From: Kathryn Welch
Sent: 09 April 2021 14:34
To: [REDACTED]
Subject: Request for further information BE/19/21/T

Q161-01 Tree Survey Plan

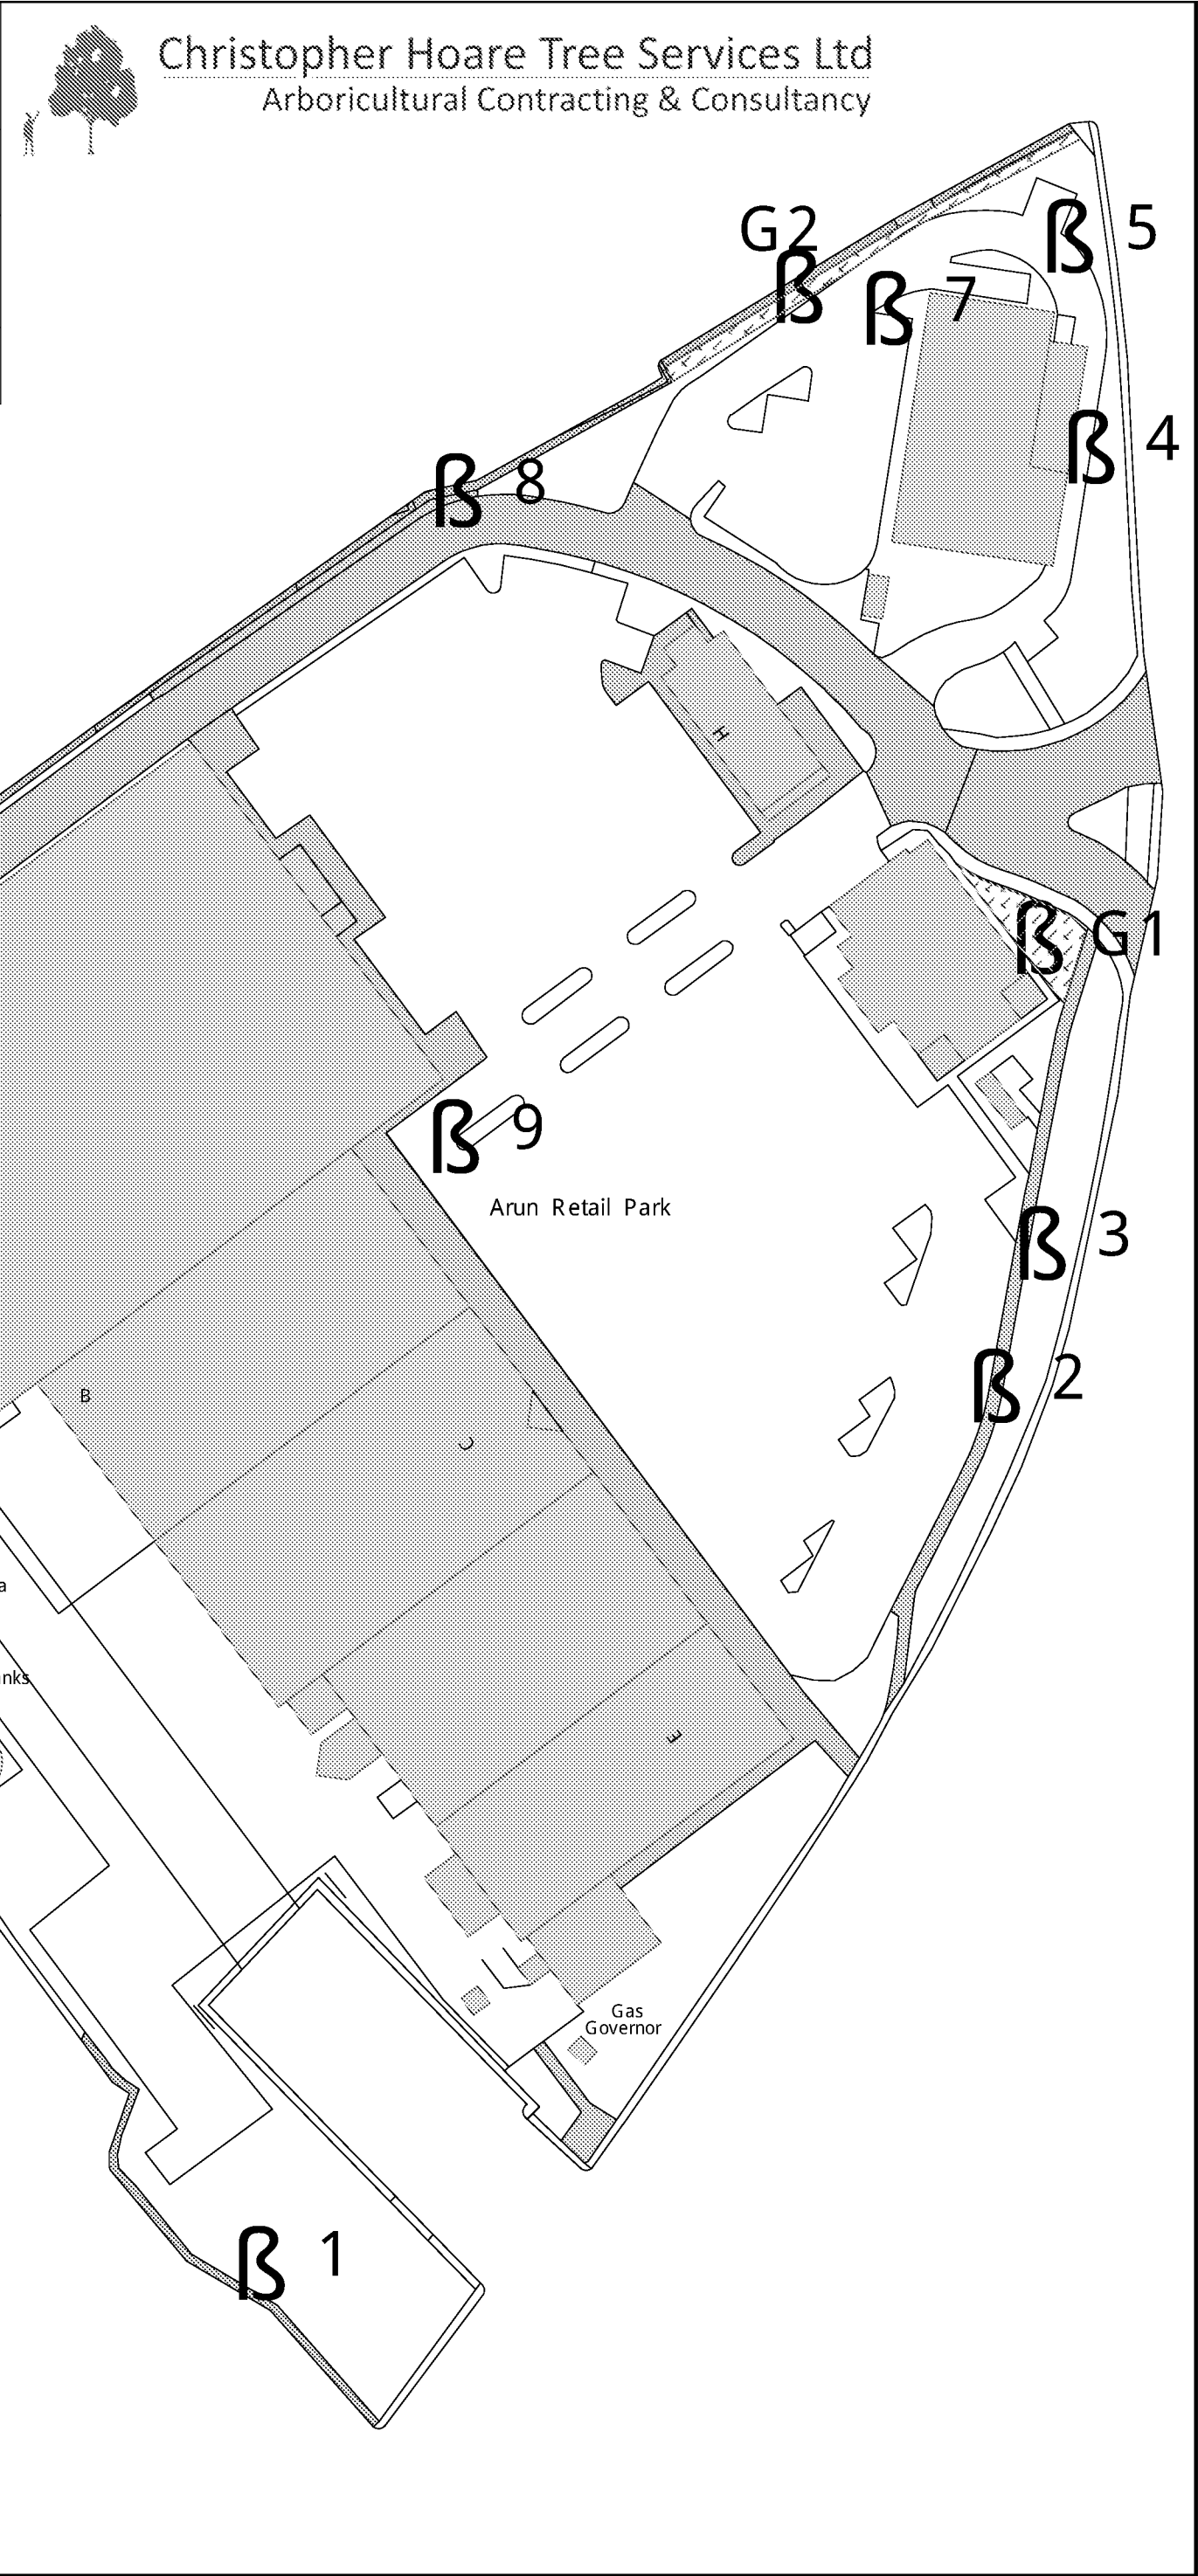
However, as noted by our invalid letter we are still also requiring the details of Tree No. 1. Could you please provide the proposed measurements of works, as ‘cut back growth’ as specified isn’t sufficient enough information for me to validate the application at this time. If you could provide the information by the 23rd I would be grateful.
